Re: SSD-17424905 – 20 Avon Road, Pymble

We refer to Development Application No. SSD-17424905 which proposes the following works:

'Redevelopment of Pymble Ladies College-Grey House Precinct, comprising a five-storey building to accommodate the following:

We write to formally submit an objection to the proposed development on the following grounds:

ISSUE
AR-DA-C10-AA-01
8

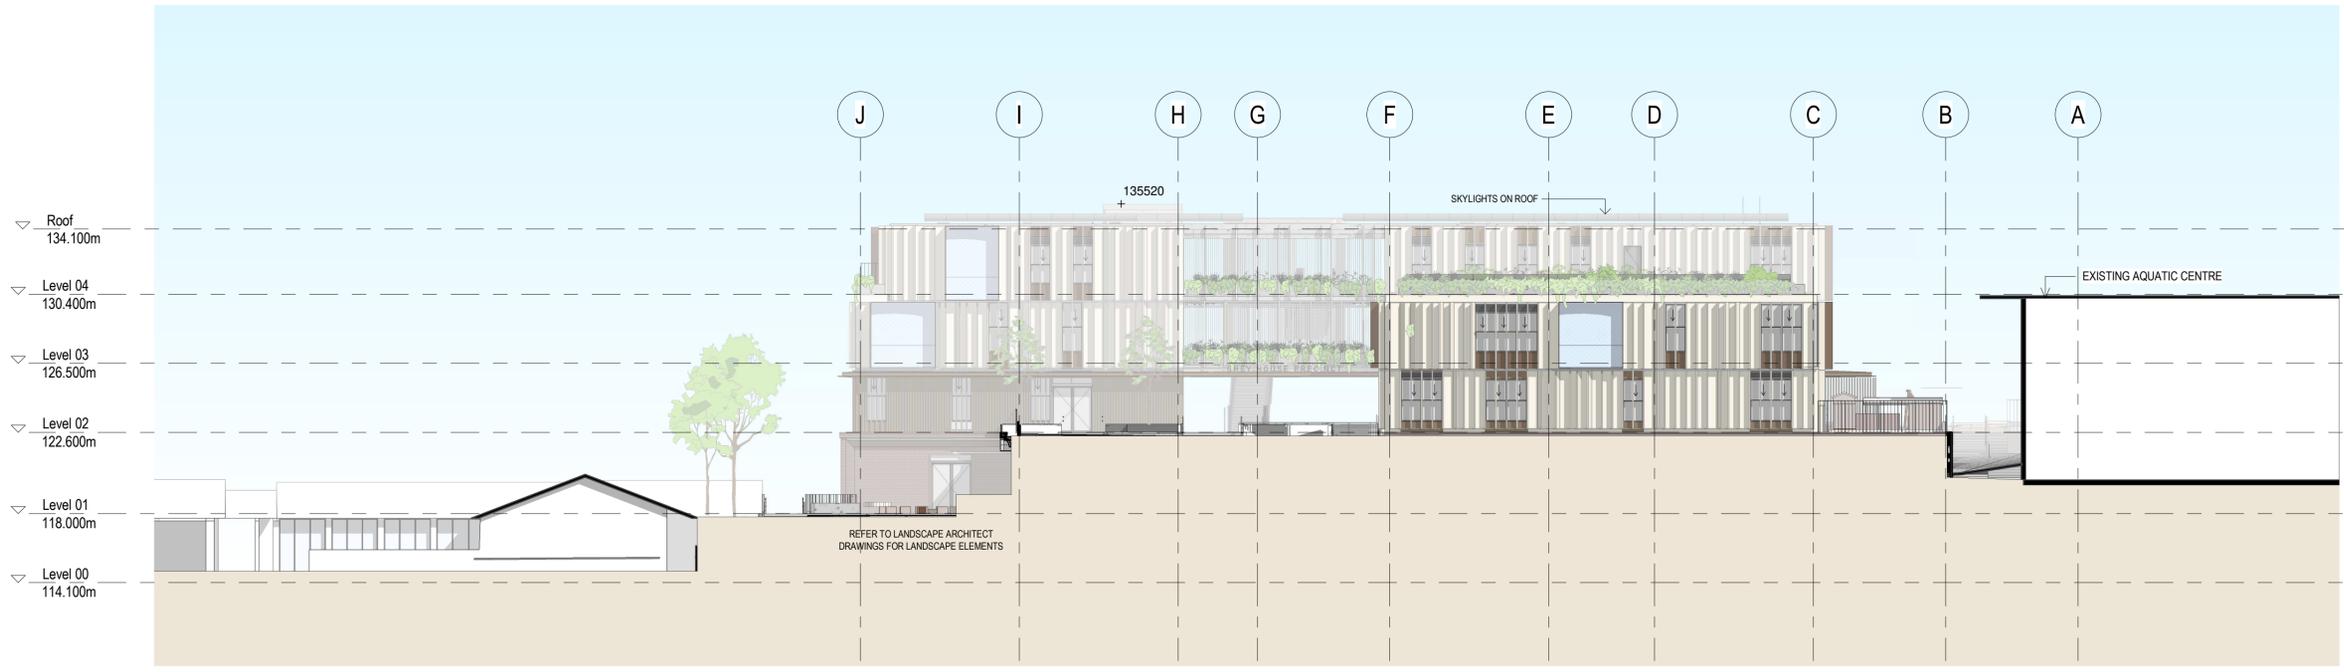
The proposed five storey (5) Grey House building is of a bulk, scale and design that is unsympathetic to the low-density residential environment to the south east. The proposed building should be amended to be of a lesser height, more recessive in design, bulk and scale and provide a transition in scale to the two (2) storey dwellings directly to the south.

Figure 2: Extract of architectural drawings showing southern elevation (Dwg. No. DA-C10-AA-01) of the proposed development (Source: BVN Architecture)

Whilst we note that no maximum building height applies to the site, the proposed 20m+ building dwarfs the surrounding single and two (2) storey residential dwellings directly to the southeast, significantly impacting on the visual privacy and visual amenity of No. 59 Pymble Avenue due to the five (5) storey scale and 62m length of the proposed southern elevation.

AR-DA-C10-AA-02 | 9

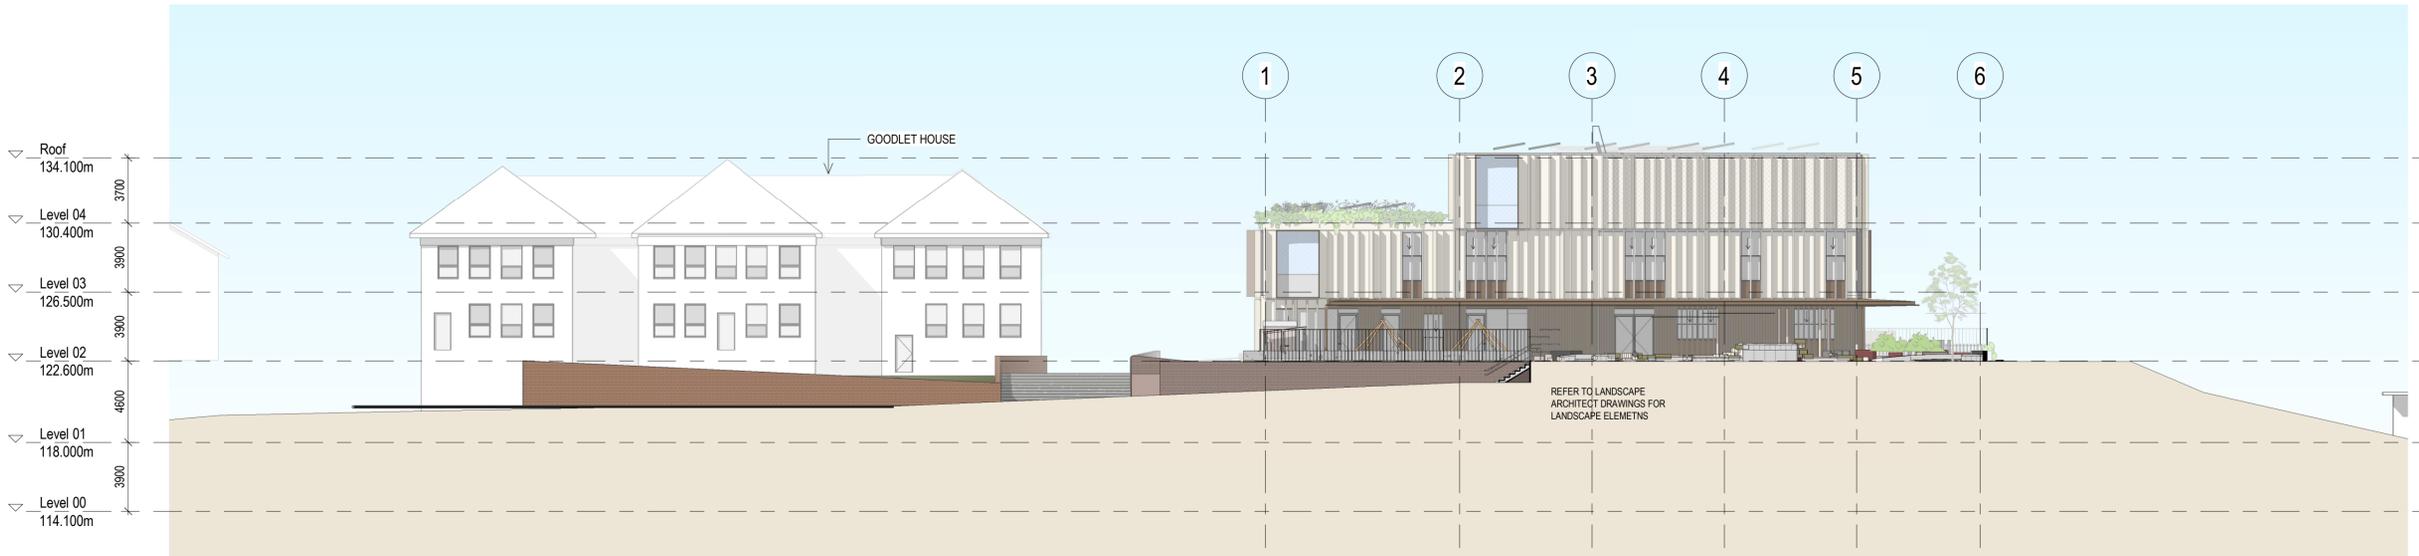
Figure 1: Extract of architectural drawings showing eastern elevation (Dwg No. DA-C10-AA-02) of the proposed development (Source: BVN Architecture)
